23 August 2012

**RE: 159 – 167 Parkdale Avenue
Transportation Brief: Addendum #1**

The following is provided in response to comments received August 3, 2012 on the above-noted Transportation Brief.

sheet title
Site Plan

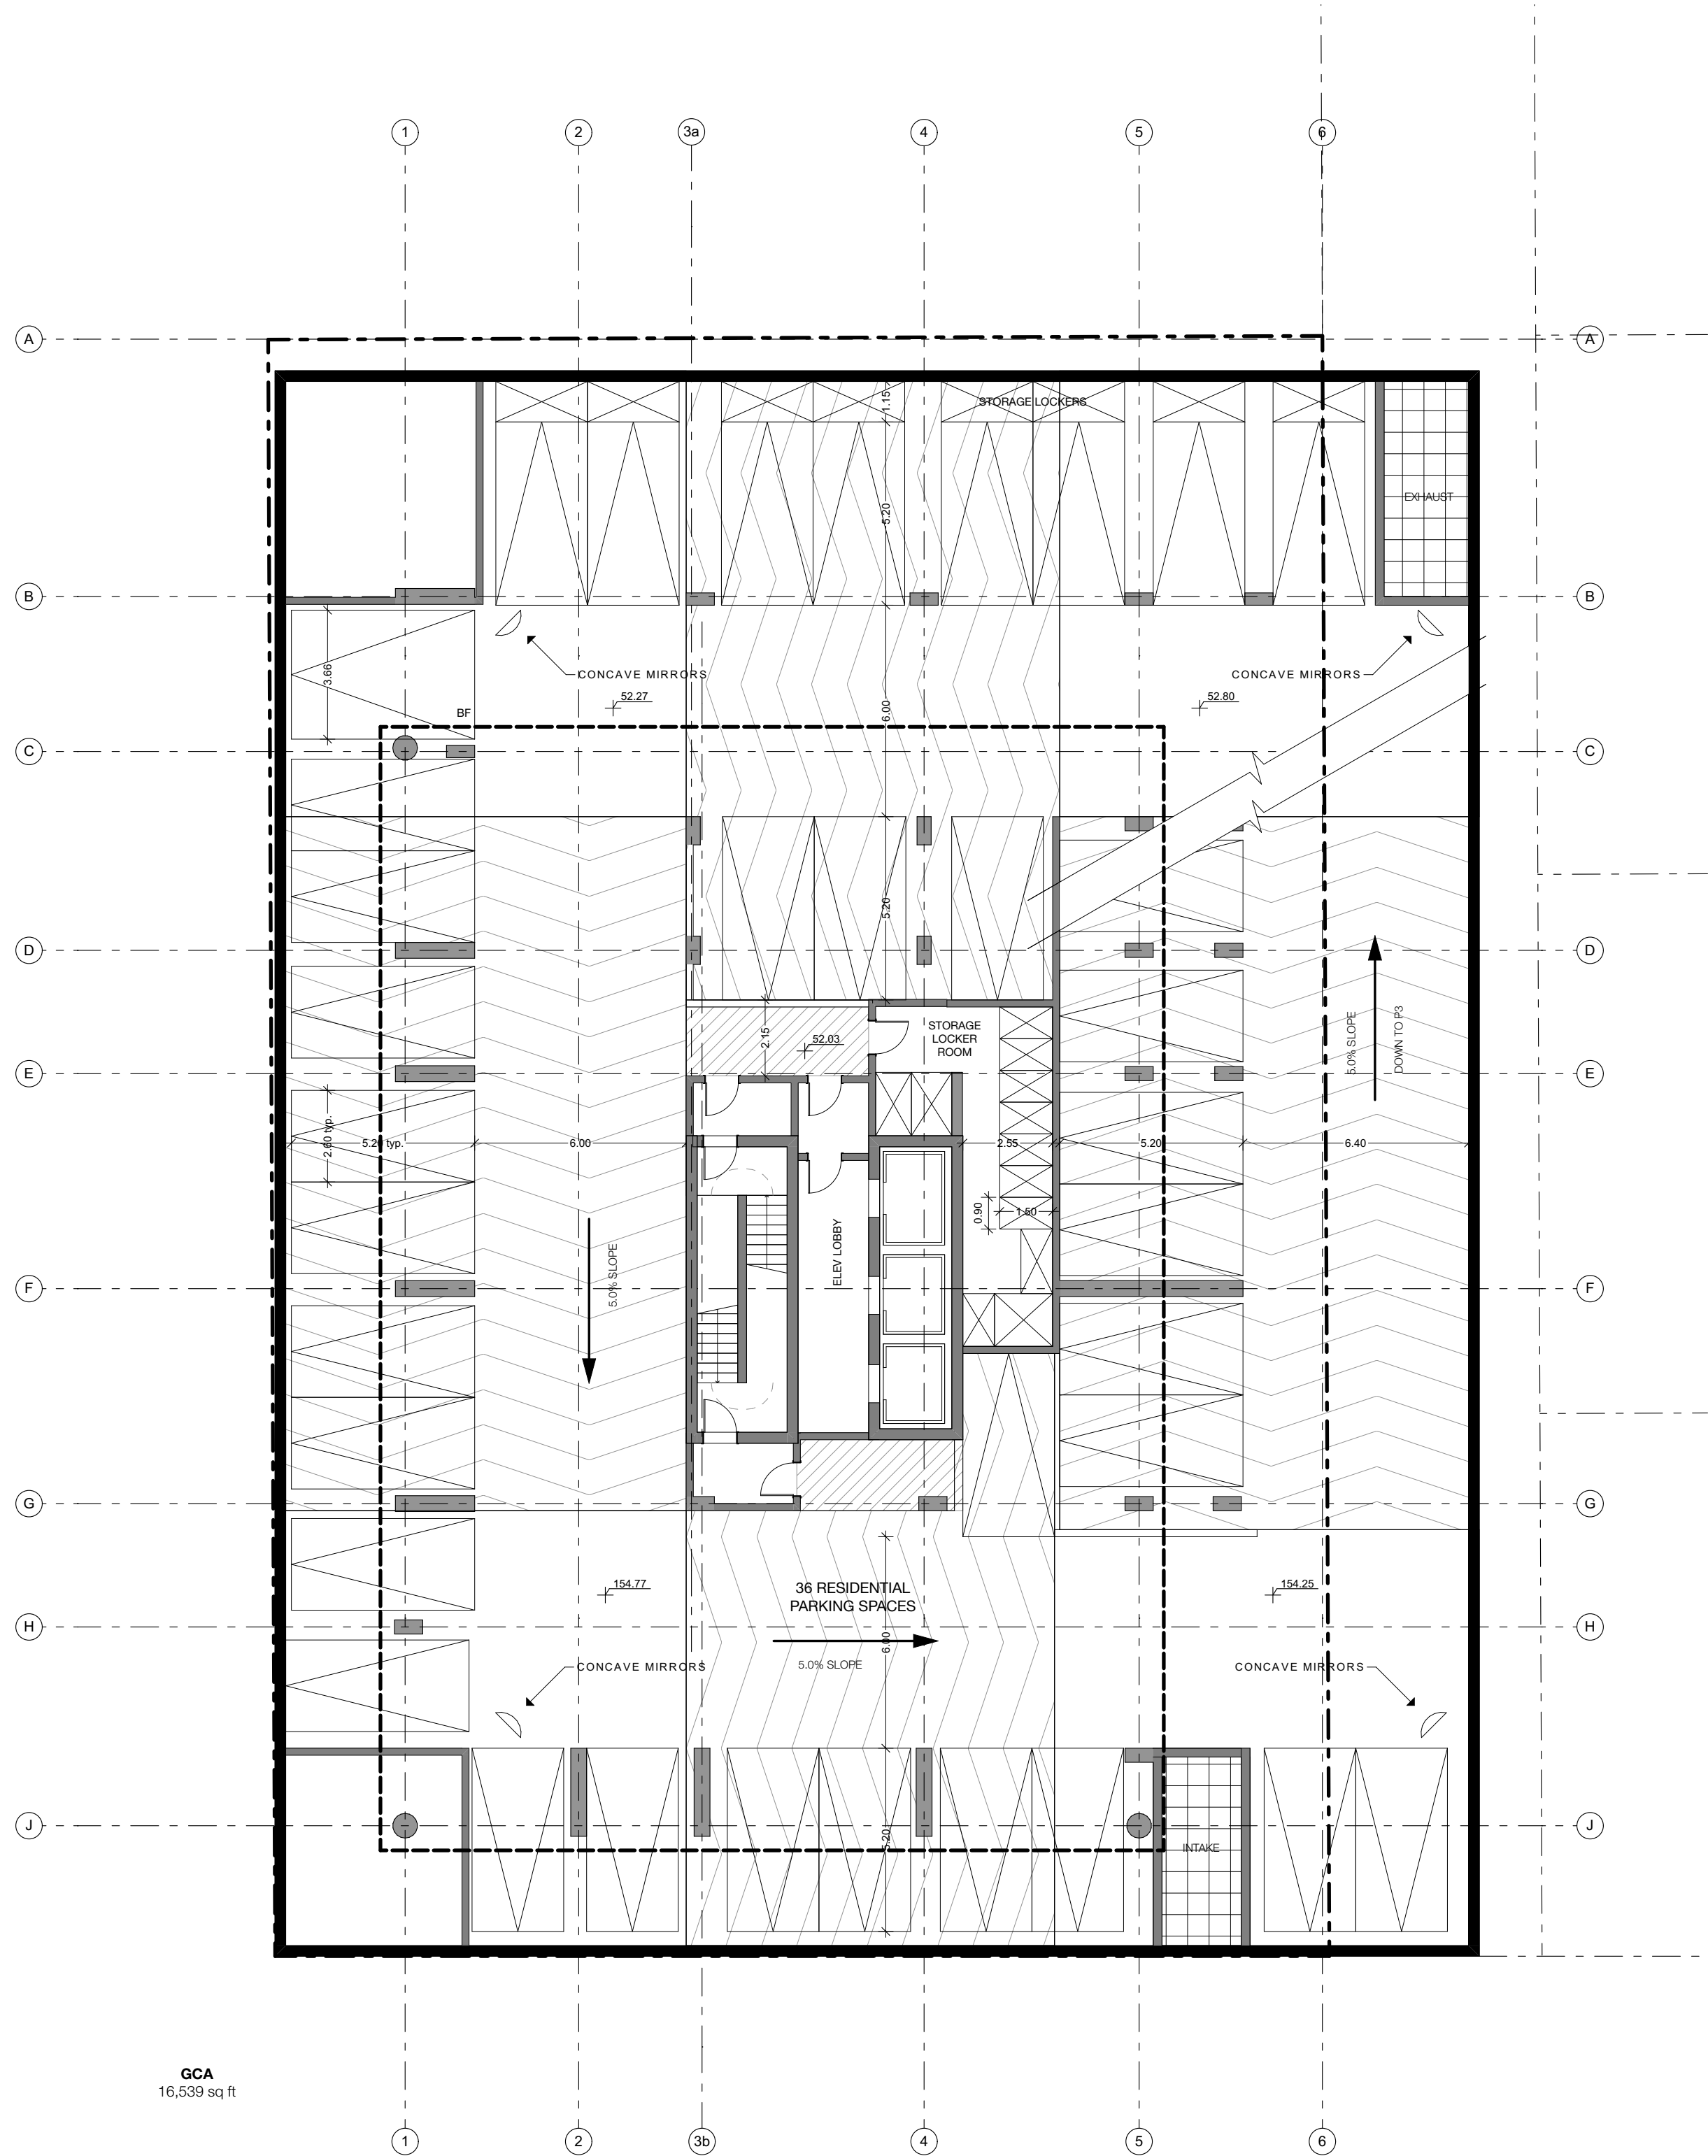
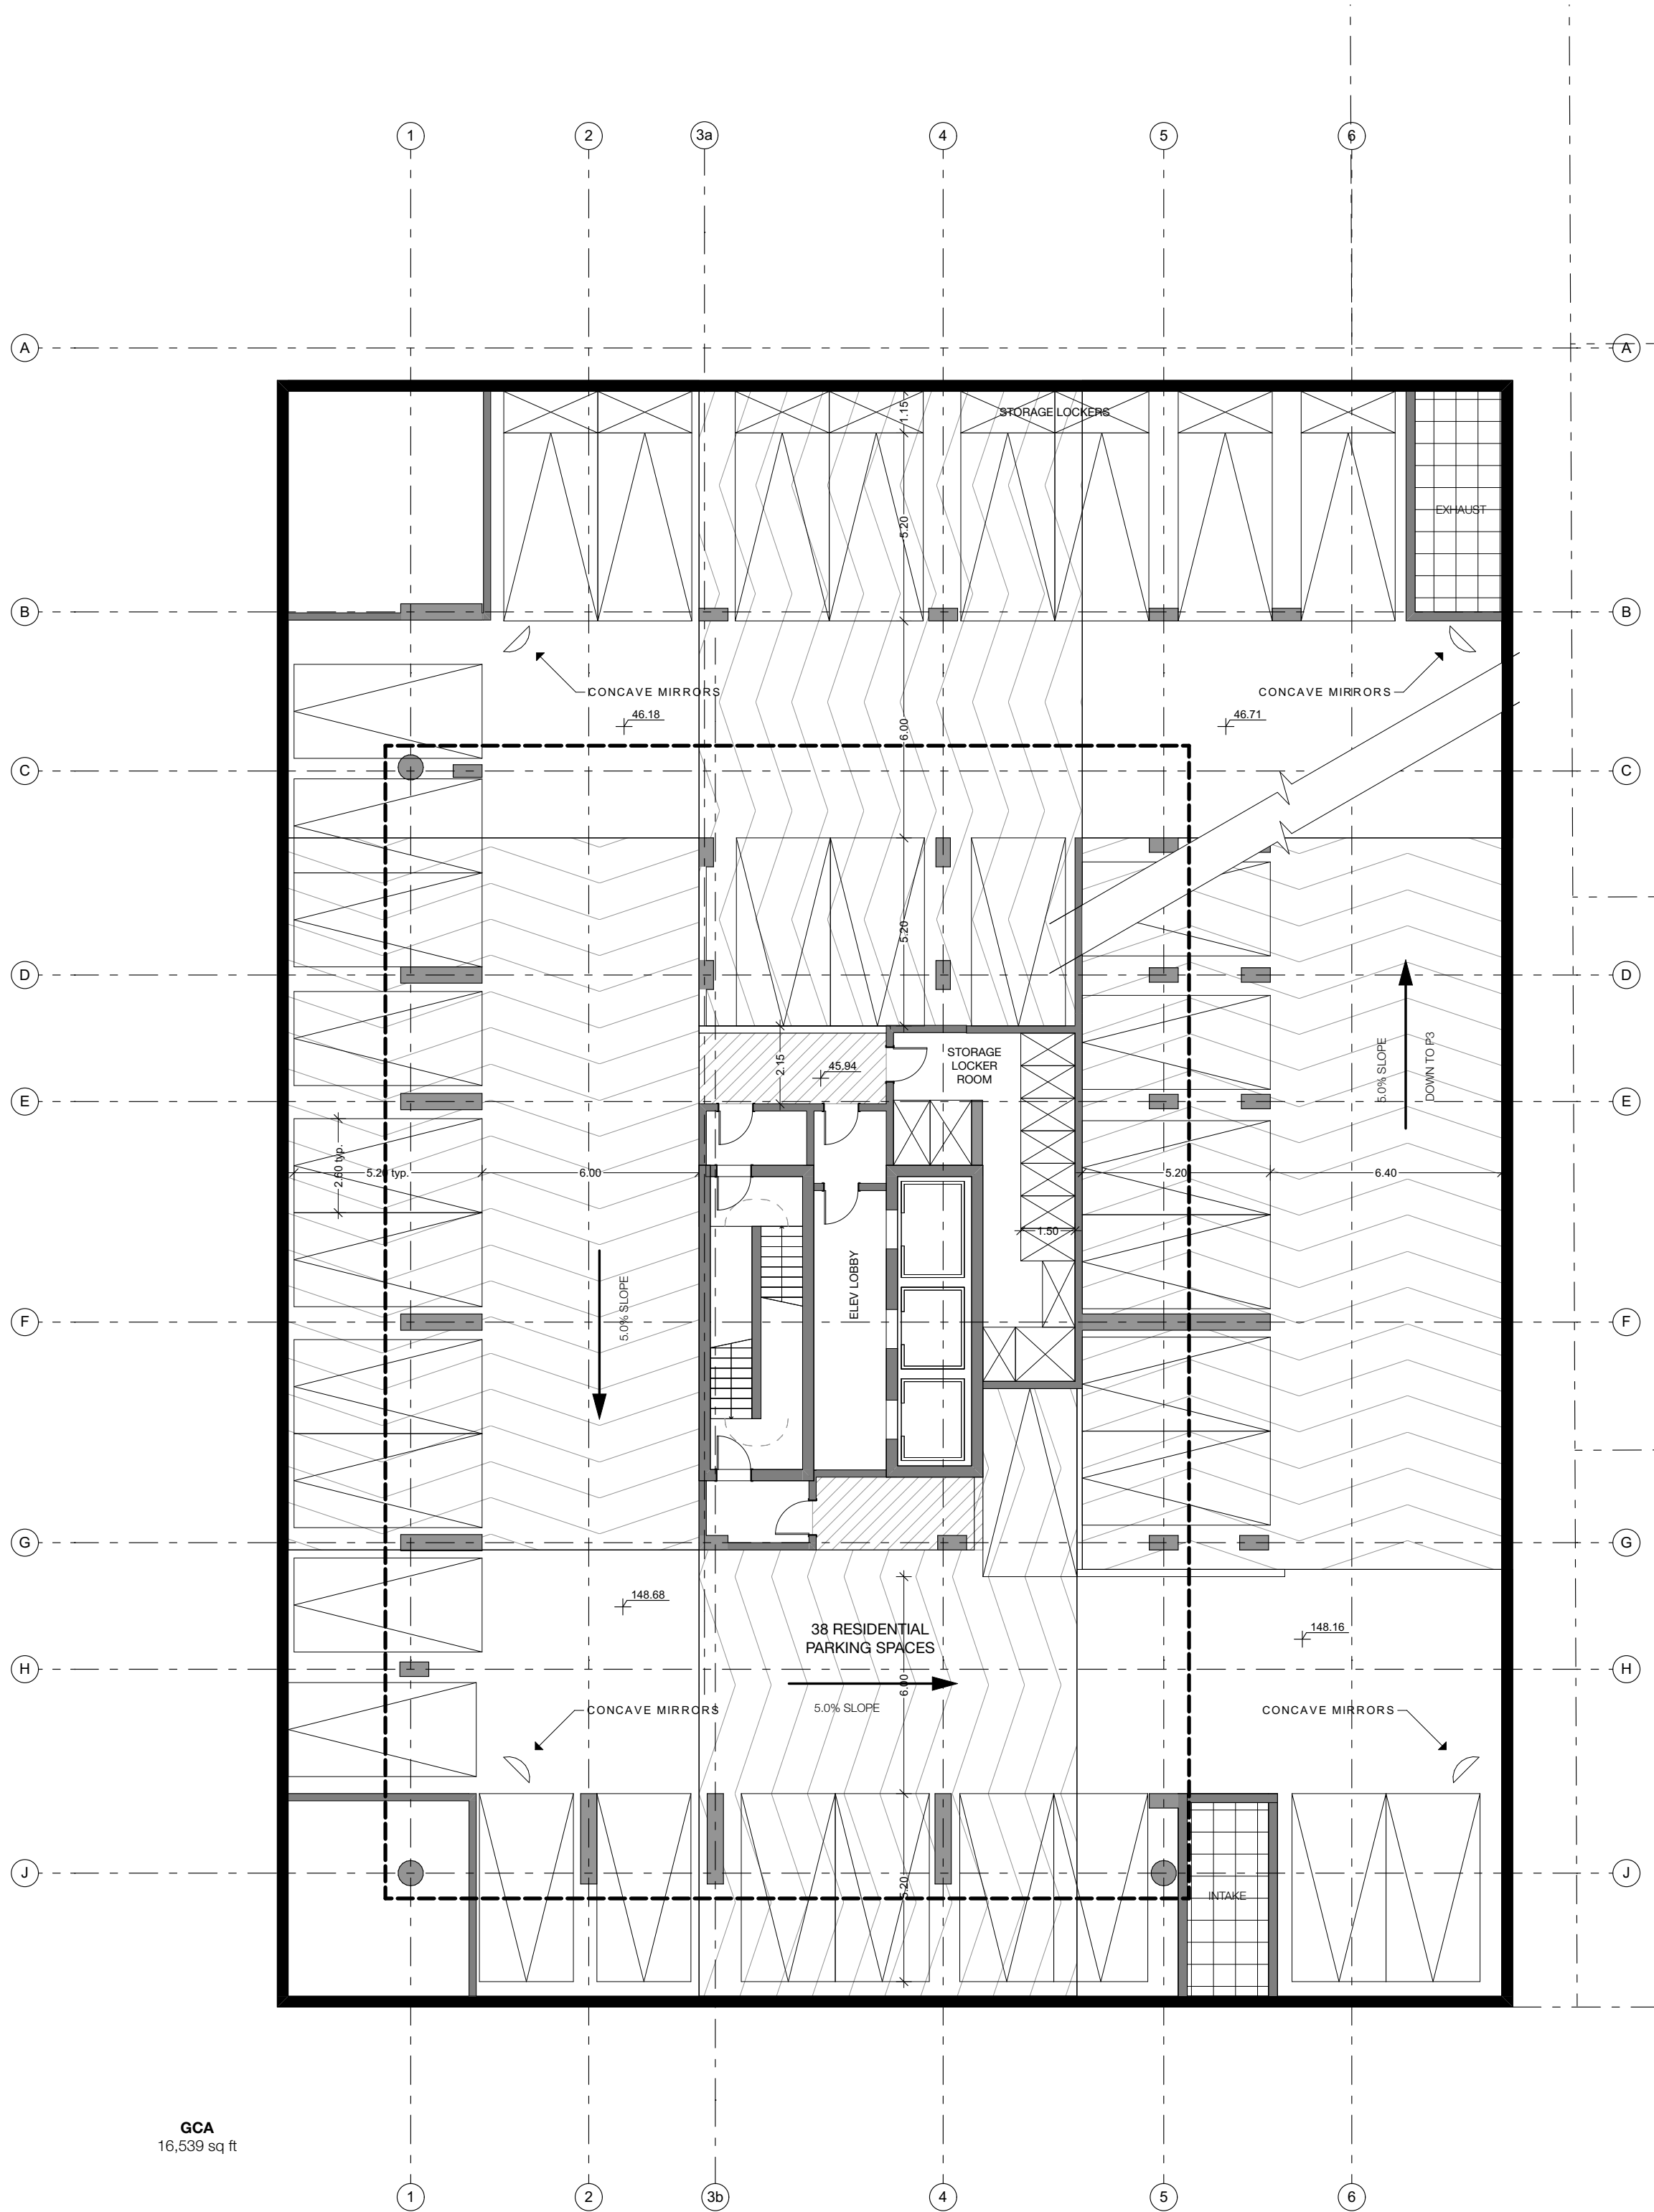
Comment 9: Site access off Lyndale Avenue is substandard in term of grade and width and it lies within 3 metres of the adjacent property line. These deficiencies are referred to in the TIA but no solution is proposed. The access will require 5.0 metre curb radii.

Response 9: The proposed width of the driveway connection to Lyndale of 6.4 m is acceptable. Our Transportation Brief was in error as the 6.7 m refers to the circulation aisle width which has 90° parking on both sides. Regarding the proposed ramp grades, they are the best that can be accommodated given the dimensions of the site. The architect will be advised to reduce the grades to the extent possible, and also that a variance is likely required.

Regarding the 5 m curb radii, the architect will be advised of this requirement.

Regarding the required 3.0 m separation between the site driveway/ramp and the property line, the City's Private Approach By-Law states that this

separation can be reduced to 0.3 m provided that the proposed access is located:

- i. a safe distance from access serving the adjacent property;
- ii. in such a manner that there are adequate sight lines for vehicles exiting the property; and
- iii. in such a manner that it does not crease any safety hazards”.

As can be seen on the Site Plan, there is a little use rear lane adjacent to the property line and it is offset by 1.54 m from the site driveway. As well, the garage door is located approximately 8 m back from the back of the Lyndale sidewalk and approximately 9.5 m from the road edge. The building face adjacent to the west of the garage door is approximately 6.5 m from the road edge.

The combination of the foregoing is such that a vehicle exiting the site driveway/garage onto Lyndale Avenue will have excellent sight lines with respect to all rear lane, sidewalk and on road pedestrian, bicycle and vehicle activity, with there being no resulting safety hazard.

As such, in this instance, a minimum 0.3 m driveway offset from the property line is in keeping with the requirements of the Private Approach By-Law and is considered safe and acceptable.
